RESPONSE TO ExA'S FURTHER QUESTIONS

**GREENSFORGE SAILING CLUB
DEADLINE 7**

Submission 7th August 2019

Appendix 2: Applicant response to Greensforge Sailing Club

Figure 3: Directional Distribution of Winds Approaching Birmingham Airport (1995 – 2015)

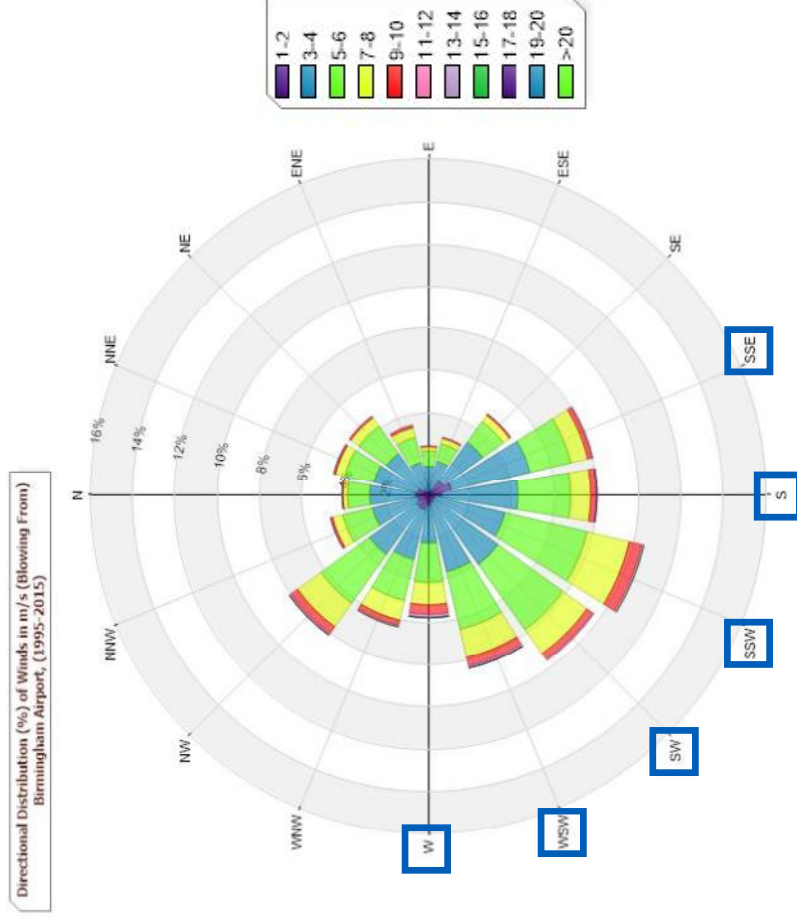
2.10	<p>“At the meeting held on 20th May (see Appendix 1), Sailing Club members advised the applicant about the ‘usual’ wind conditions on the reservoir. This was intended to assist their understanding of the conditions usually realised, and to ensure that the model accurately reflected this position. It is noted that RWDI nor Wolfson Unit have chosen to visit the site prior to the issue of the reports, in order that they can confirm that the conditions identified in the modelling accurately reflect site reality.”</p> <p>The Sailing Club note that neither RWDI nor the Wolfson Unit have taken the opportunity to sail at the Club to consider the wind conditions for themselves before or after undertaking the computational analysis.</p> <p>The Club firmly believe that a prior site visit by both consultancies would have assisted their understanding of the site and the way in which the wind behaves across the reservoir, The Sailing Club note that the Wolfson Unit visit for the meeting on 20th May was to discuss the results of the analysis only. No specific interest in the reservoir or conditions impacting upon it was demonstrated during that visit.</p> <p>On 31st July 2019, the wind was directly westward, and as a result the Club members took measurements of wind direction relative to north whilst sailing on the lake. The results are mapped on the plan in Appendix One. This clearly shows that the wind curves across the site, and that the original suggestion to the Applicant was indeed accurate. This primary empirical evidence is important in understanding how the wind behaves across the site.</p>	2.10	<p>Using the proposed approach, which is considered a reasonable scientific method, a prior site visit would not have provided any benefit to the modelling. The visits on-site have assisted the applicant with understanding the operations / activities at the sailing club and interpreting the effects of the results, although this doesn’t affect the CFD modelling undertaken. It is considered best to use a recognised modelling approach for the consistency of the output, which in this instance is based on 30 years (1995-2015) of wind data, rather than use an arbitrary site visit.</p>

Figure 6 Configuration 1 (EXISTING SURROUNDINGS): Sailing Quality (%)

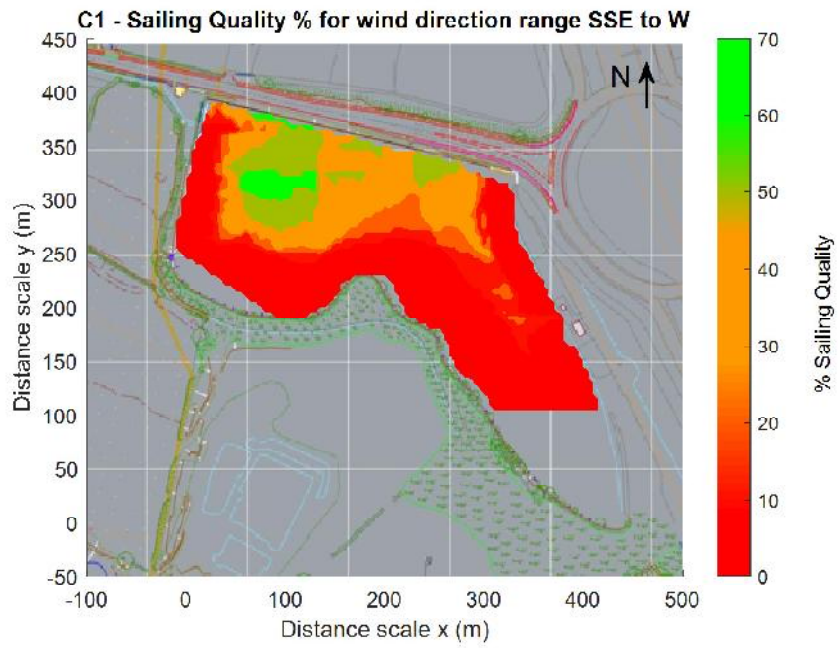
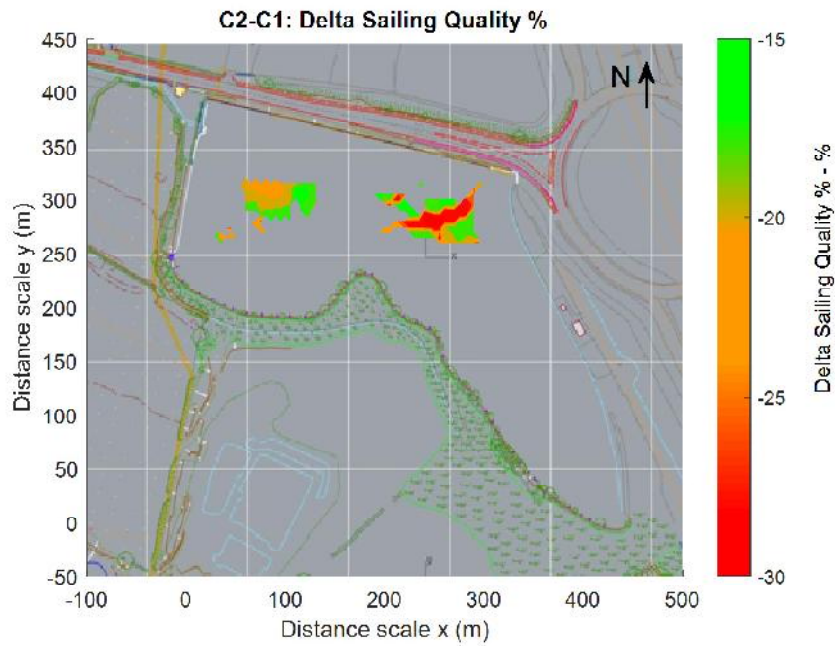
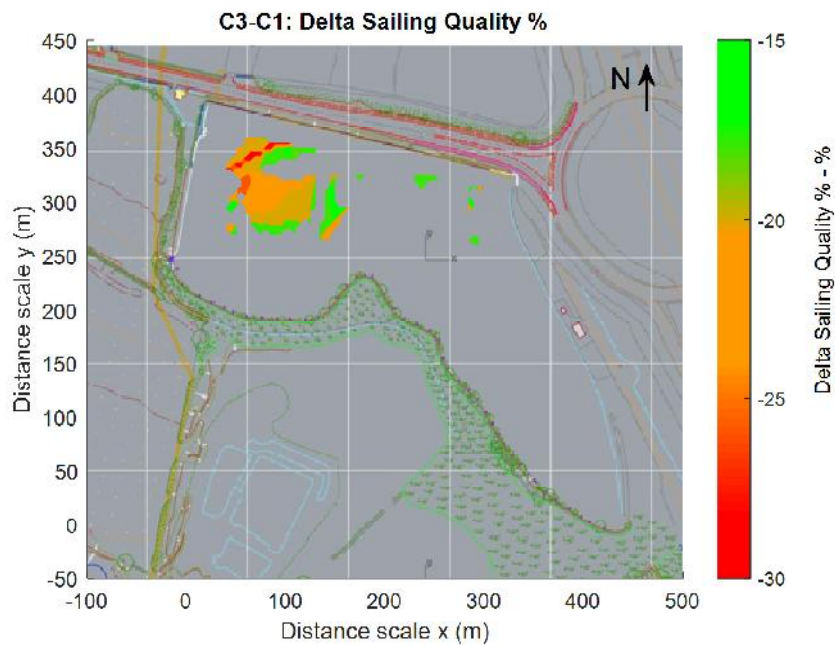
<p>The conclusions to the report indicate that the localized areas impacted equate to 11.3% and 13.5% of the sailing area respectively. Figures 14 and 15 show the areas most affected, and when compared with the baseline Figure 6 show that the best sailing areas will be most impacted.</p> <p>The Wolfson Unit show that in either development scenario there will be a reduction in wind speed, which in itself will have an impact upon novice sailors, who will find transition difficult to assess as well as dealing with significant gusts which also make sailing difficult.</p> <p>The Wolfson Unit do not consider the impact arising when the 80th percentile wind speeds are considered. This is likely to have a greater impact on more experienced sailors, who make up the majority of the Club membership. Any potential reduction in wind speeds is likely to generate significant frustration due to the lack of challenge. In addition, the experienced sailor will also suffer from the reduction in sailing quality in the best parts of the reservoir. This is likely to reduce the pleasure that experienced sailors obtain from the challenges generated by the environment.</p> <p>It is important in any assessment that the full range of users are properly considered. As it currently stands, the assessment fails to do this.</p>
